WEST SUSSEX COUNTY COUNCIL CONSULTATION

TO:	Arun District Council FAO: Maria Tomalova
FROM:	WSCC - Highways Authority
DATE:	14 April 2022
LOCATION:	Salisbury House The Steyne Bognor Regis PO21 1TX
SUBJECT:	BR/65/22/L Listed building consent for the change of use of 5 No self-contained flats for adults with learning difficulties to 5 No self-contained flats and formation of 5 No further flats from HMO rooms, garage and office, repairs and decoration of external surfaces, minor alterations to elevation facing Sadler Street, change one window facing rear courtyard to French doors & apply obscure film to 2 windows in courtyard area.
DATE OF SITE VISIT:	n/a
RECOMMENDATION:	Advice
S106 CONTRIBUTION TOTAL:	n/a

GROUND FLOOR

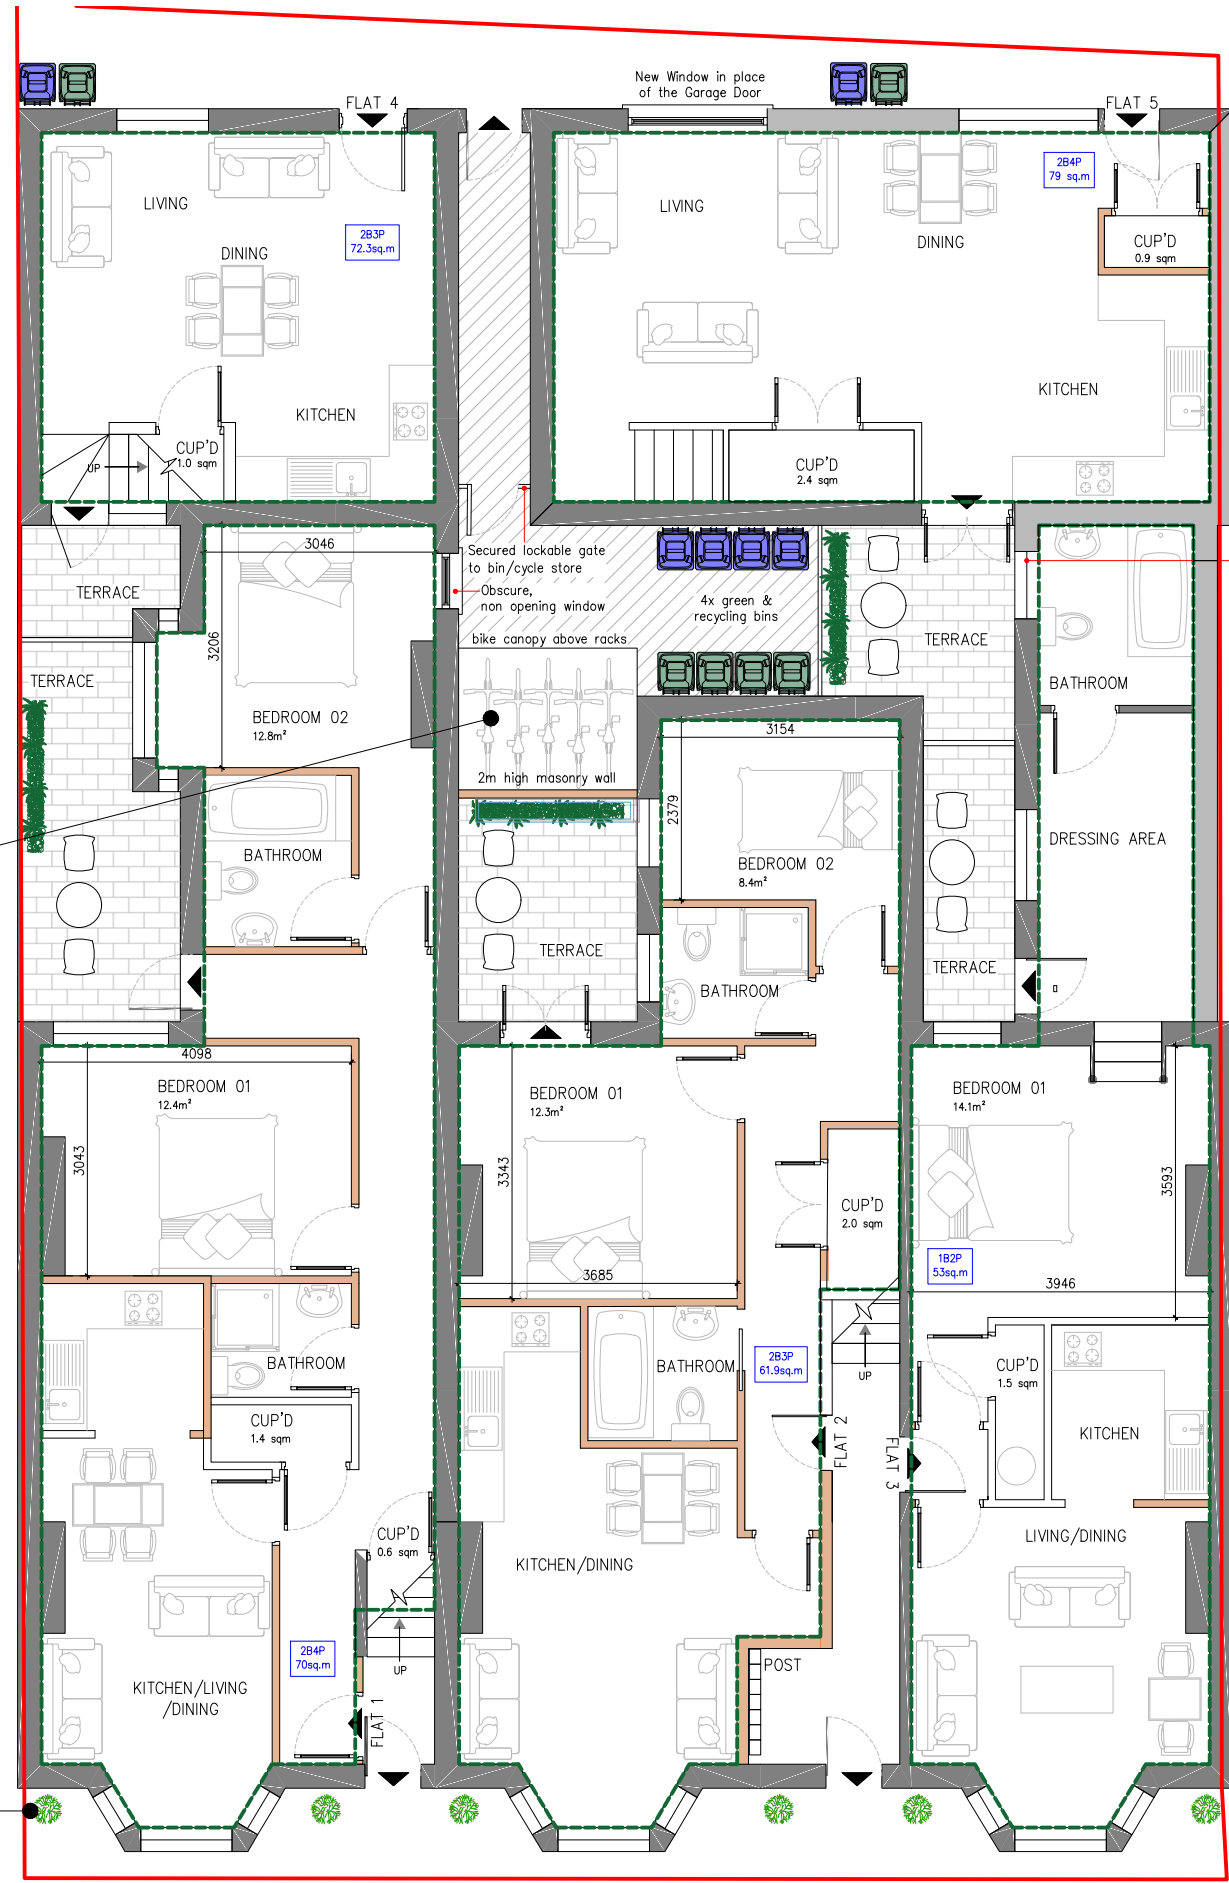
The site is sustainably located within the centre of Bognor Regis, within proximity to a variety of local shops, services and public transport links which reduce the reliance upon the private car. Cycle storage is proposed for up to 10 cycles within a two-storey racking system. Whilst the LHA acknowledge that this is not the most convenient storage solution for residents; given the site constraints and that the racks will be covered and the cycle/bin store area will be secure, the LHA would accept the proposed arrangements.

No part of the development shall be first occupied until covered and secure cycle parking spaces have been provided in accordance with the proposed plan.
